**Notice of Decision
Town and Country Planning Act 1990
Town and Country Planning (Development
Management Procedure) (England) Order 2015
Approval of Permission for Development**

Application No: 6/2019/2313/FULL

Development: Erection of six dwellings following demolition of existing buildings

At Location: 101 Brookmans Avenue, Brookmans Park, Hatfield, AL9 7QG

Drawing Title
PROPOSED SITE PLAN

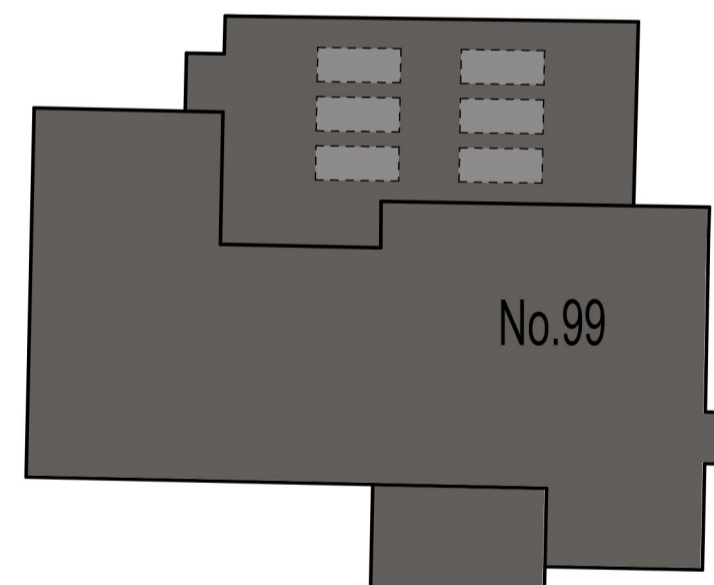
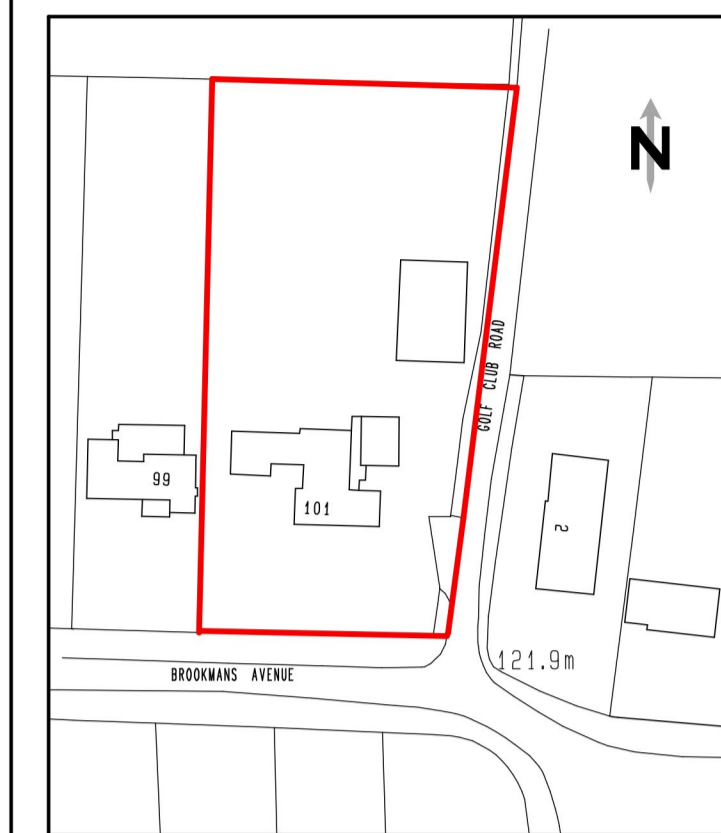
4. Prior to first occupation of the development hereby approved, vehicular access must be provided and thereafter retained at the positions shown on drawing number 485018-16 Rev B. Arrangements must be made for surface water drainage to be intercepted and disposed of separately so that it does not discharge from or onto the highway carriageway.

Drawing Title
 TYPICAL CROWN ROOF DETAILS

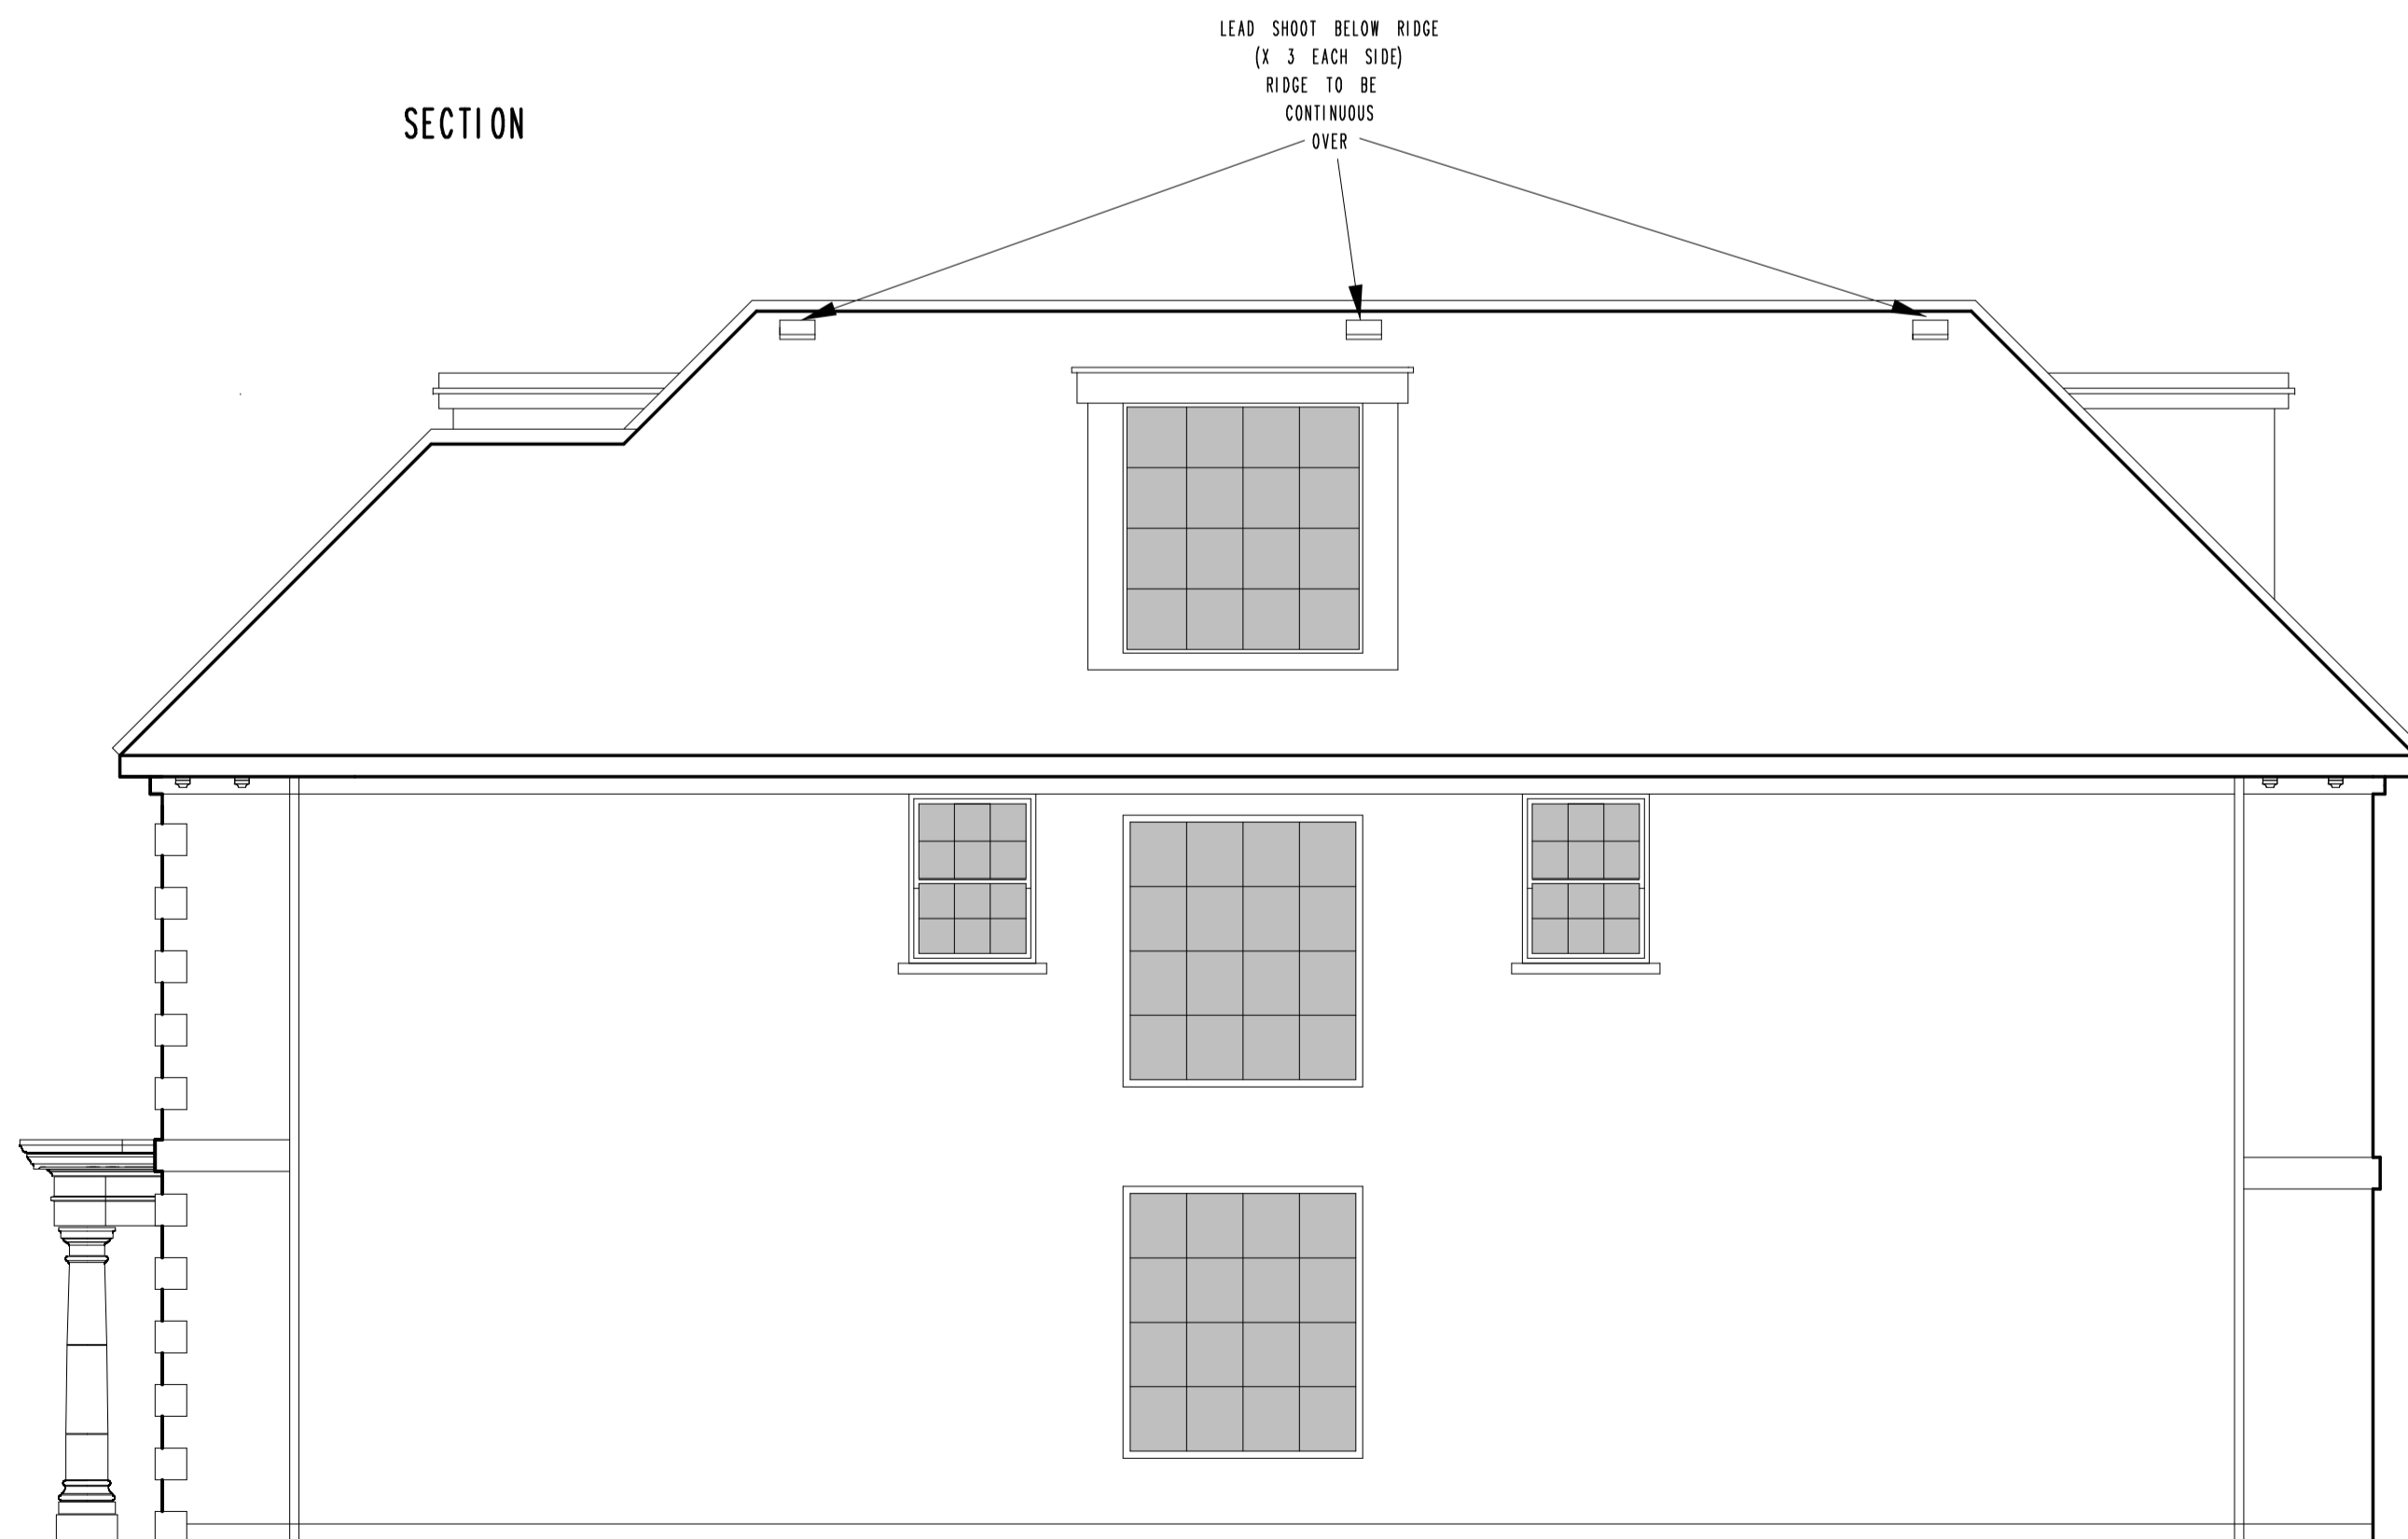
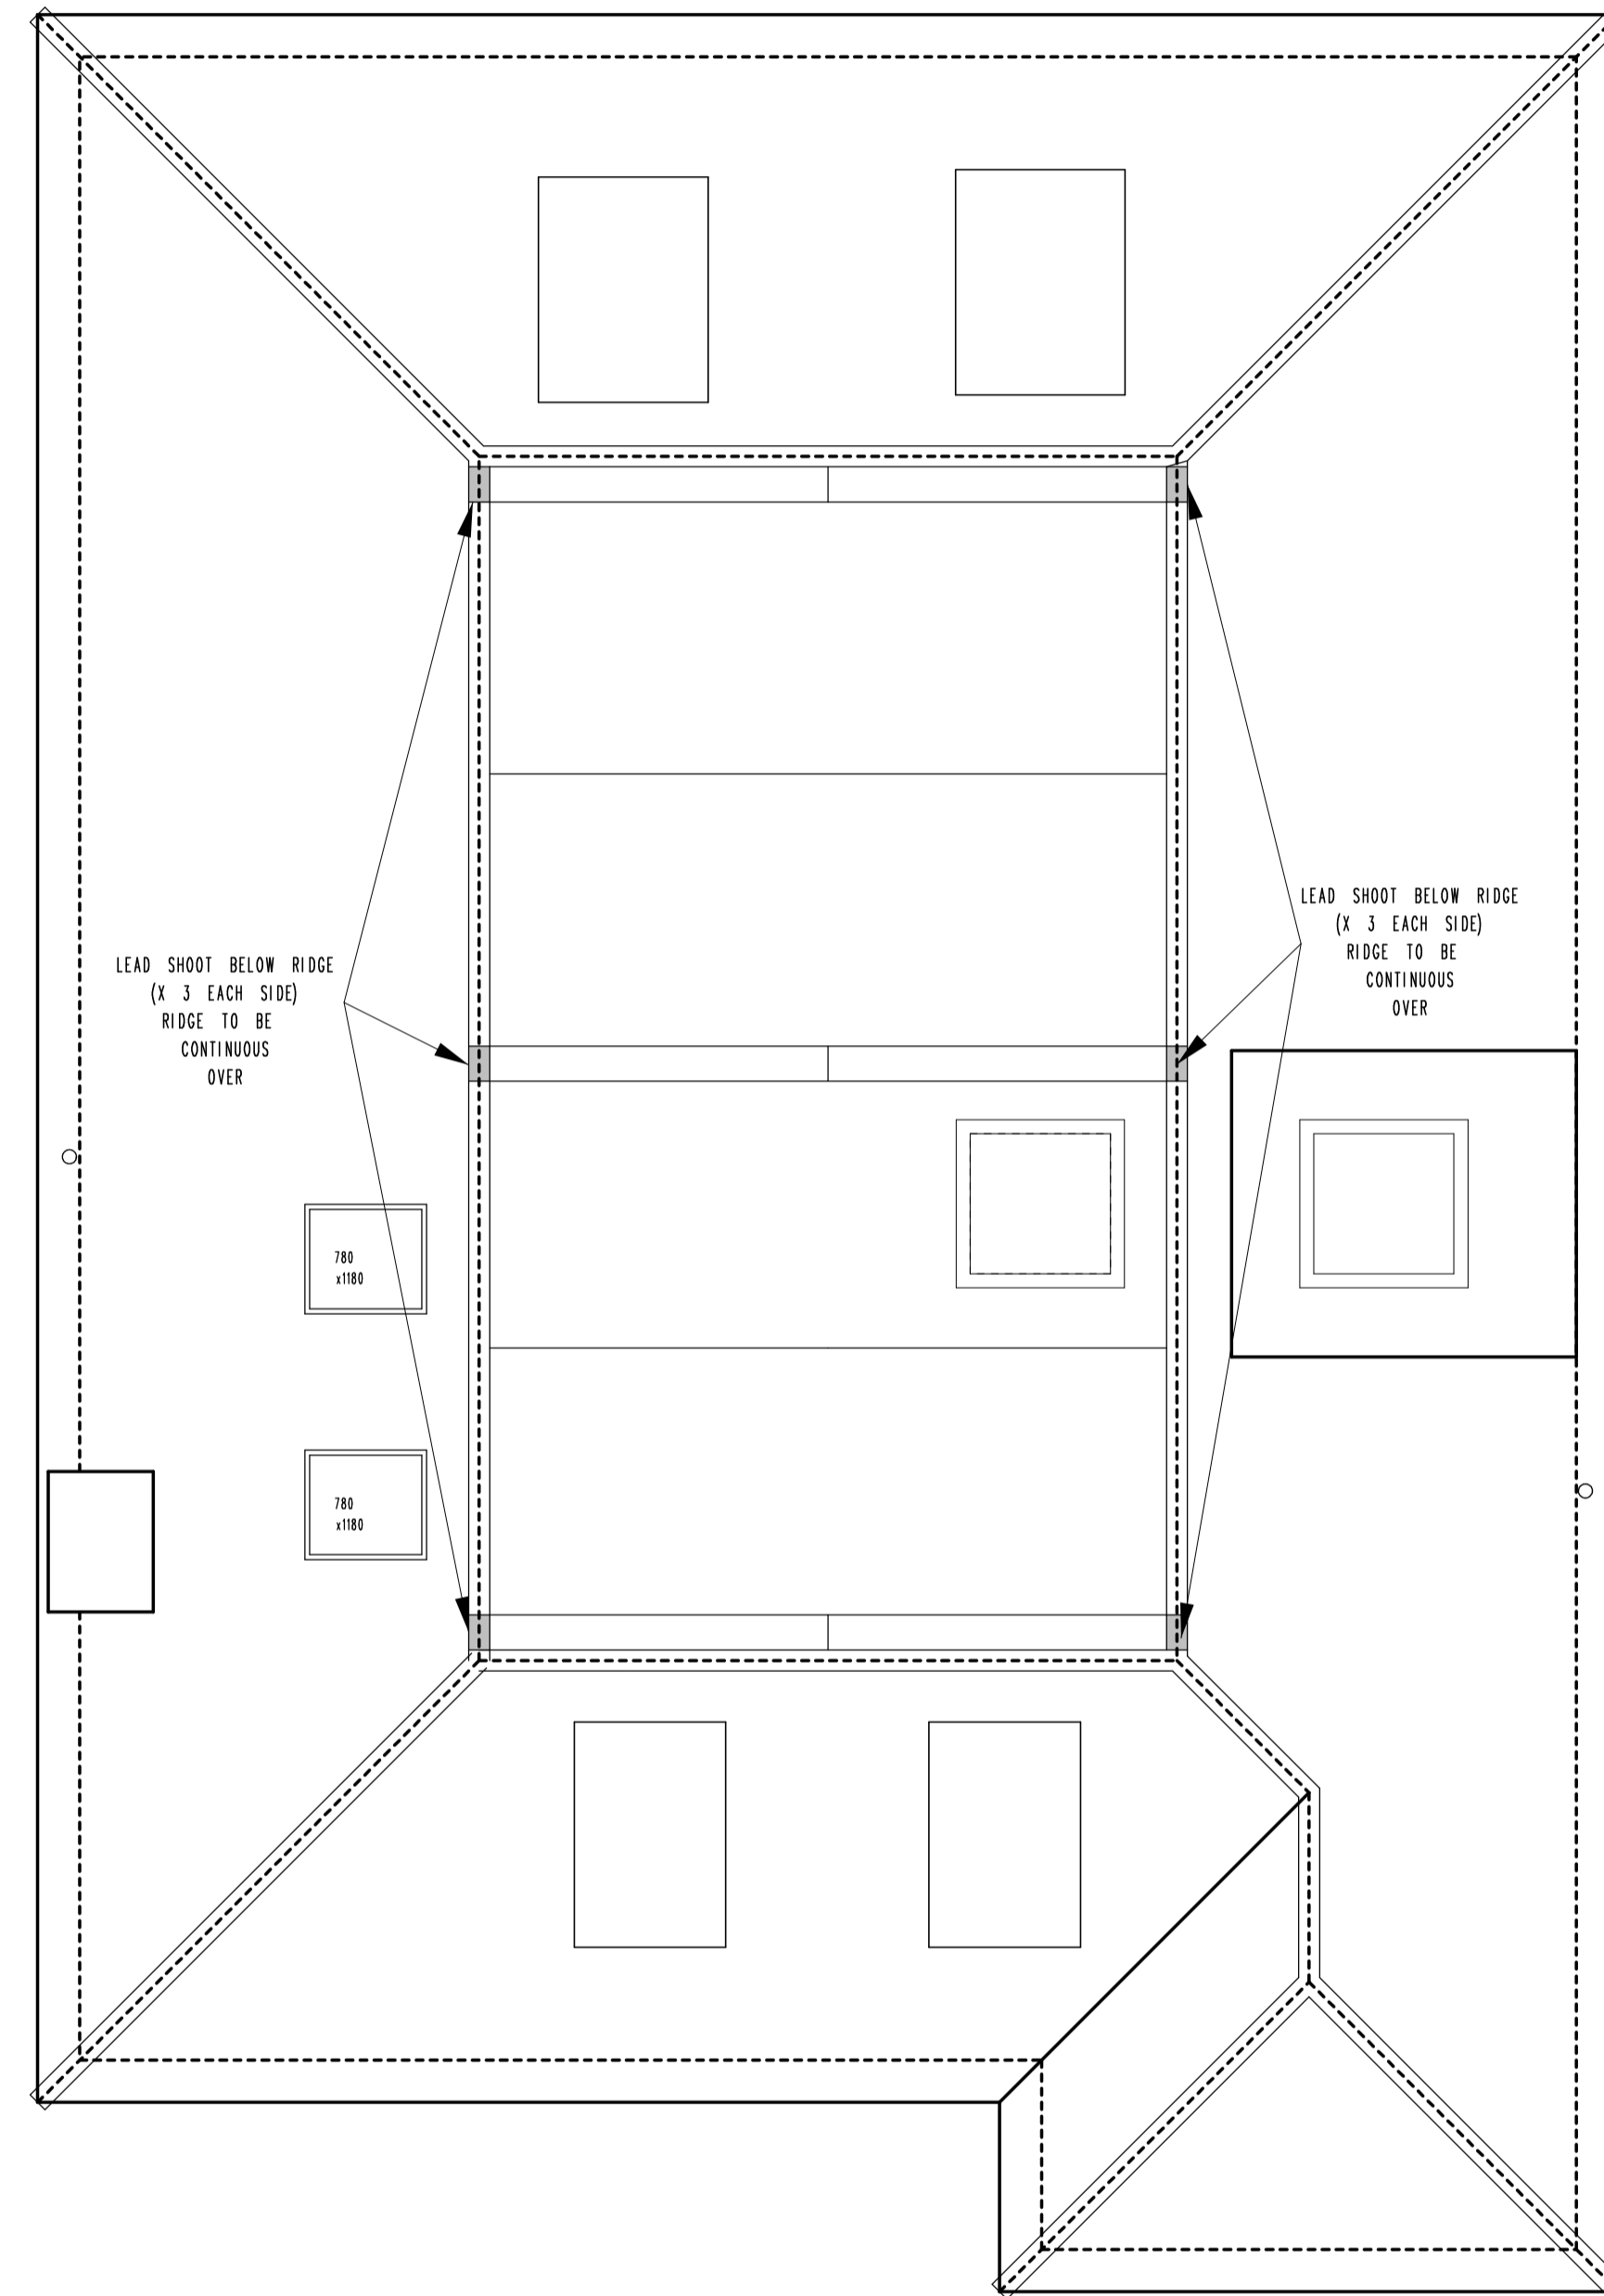
1. Notwithstanding submitted drawing number: 48 5018-26, relating to crown roof details, no development above ground level shall take place until amended details of the proposed crown roof have been submitted to and approved in writing by the Local Planning Authority. The details, including; a roof plan, elevations and sections, in either 1:50 or 1:100 scale, and applying to all dwellings, must clearly show that the flat roof is stepped down and concealed behind the surrounding pitched roof. The pitched roof must use ridge tiles. Subsequently the development must be carried out in accordance with the approved details.
